Recommendation Report for Planning Permission for Works or Extension to a Dwelling

REF NO: F/13/21/HH

LOCATION: 43 Johnson Way
Ford
BN18 0TD

PROPOSAL: Erection of single storey side extension following the demolition of existing conservatory

extending homes Tel:- 01243 555208 enquiries@extendinghomes.co.uk	
TITLE:- Rear Extension @ 43 Johnson Way Ford West Sussex BN18 0TD	
DATE:-	6th July 2021
SCALE:-	Elevations Scale 1-100 on A1 Paper
DRAWN:-	P.Robinson
DWG. No. 2021066/PL/1

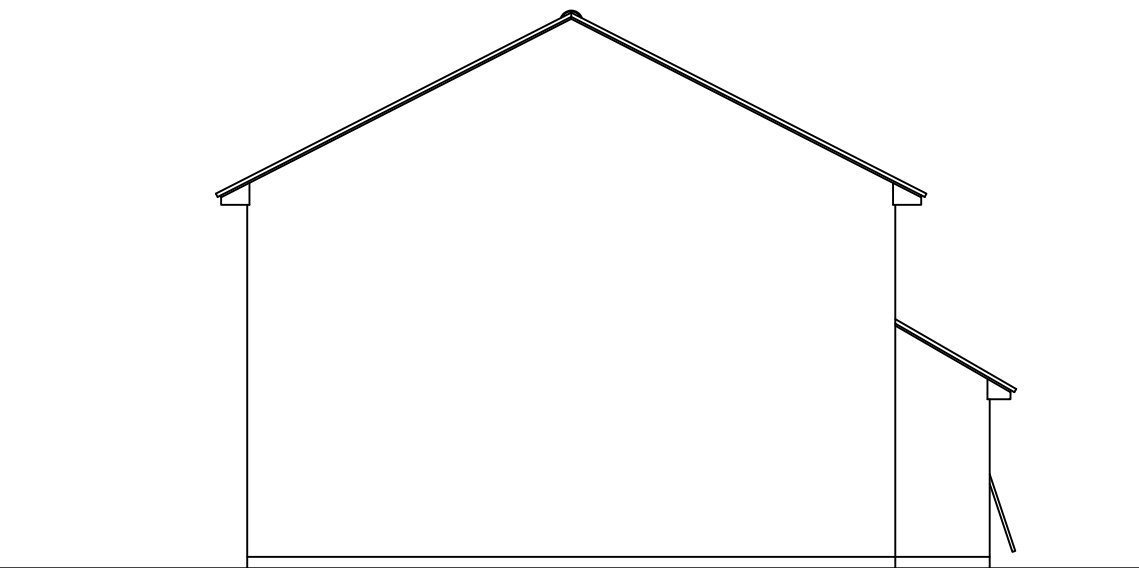
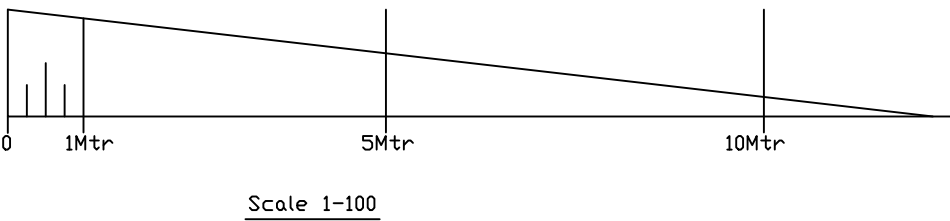
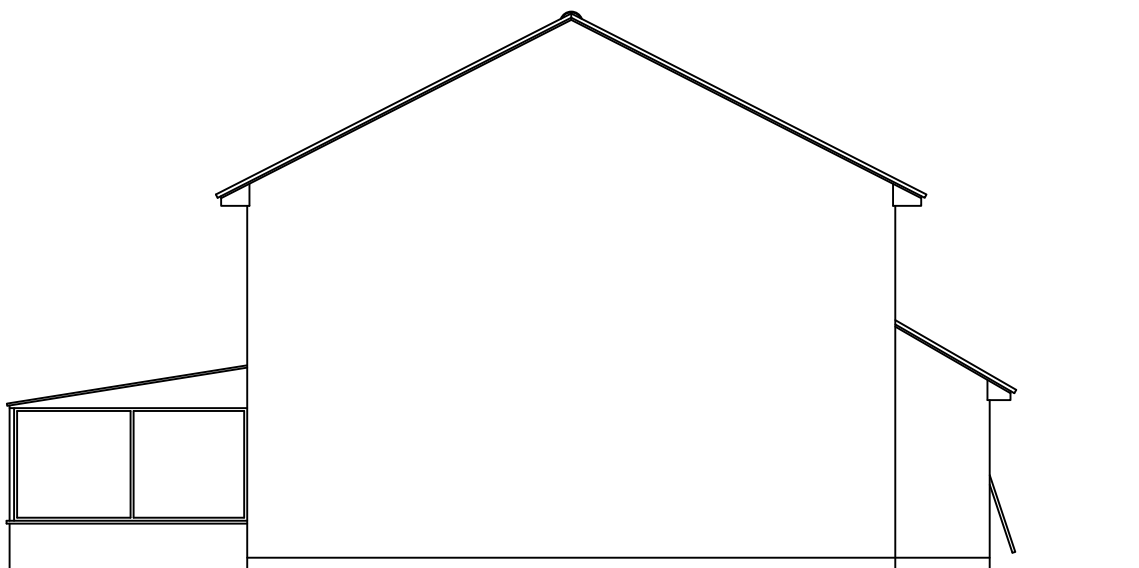
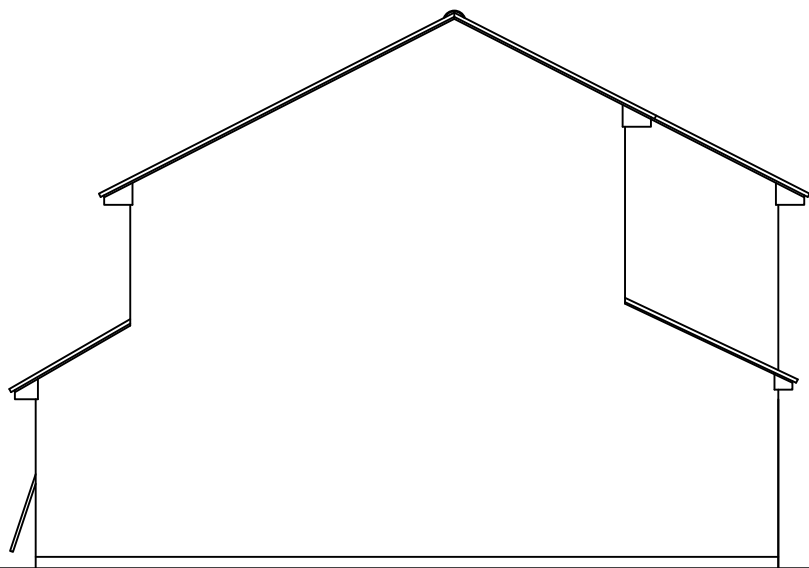
There is an existing conservatory which runs along the rear elevation with a depth of 3m. This will be removed and a side extension will be constructed which infills the northern elevation.

The extension is modest in size, with a depth of 2m, meeting with the original rear elevation of the property. It will have a width of 2.7m meeting with the side elevation and will have a sloping roof.

The extension will have a depth of 2m and a width of 2.7m infilling the rear northern side of the dwelling. There will be a maximum of height of 3.6m with an eaves height to 2.4m. Due to the location of the extension, it is not considered to appear overbearing or overshadowing.

There will be one window facing west which will overlook the garden of the host dwelling.
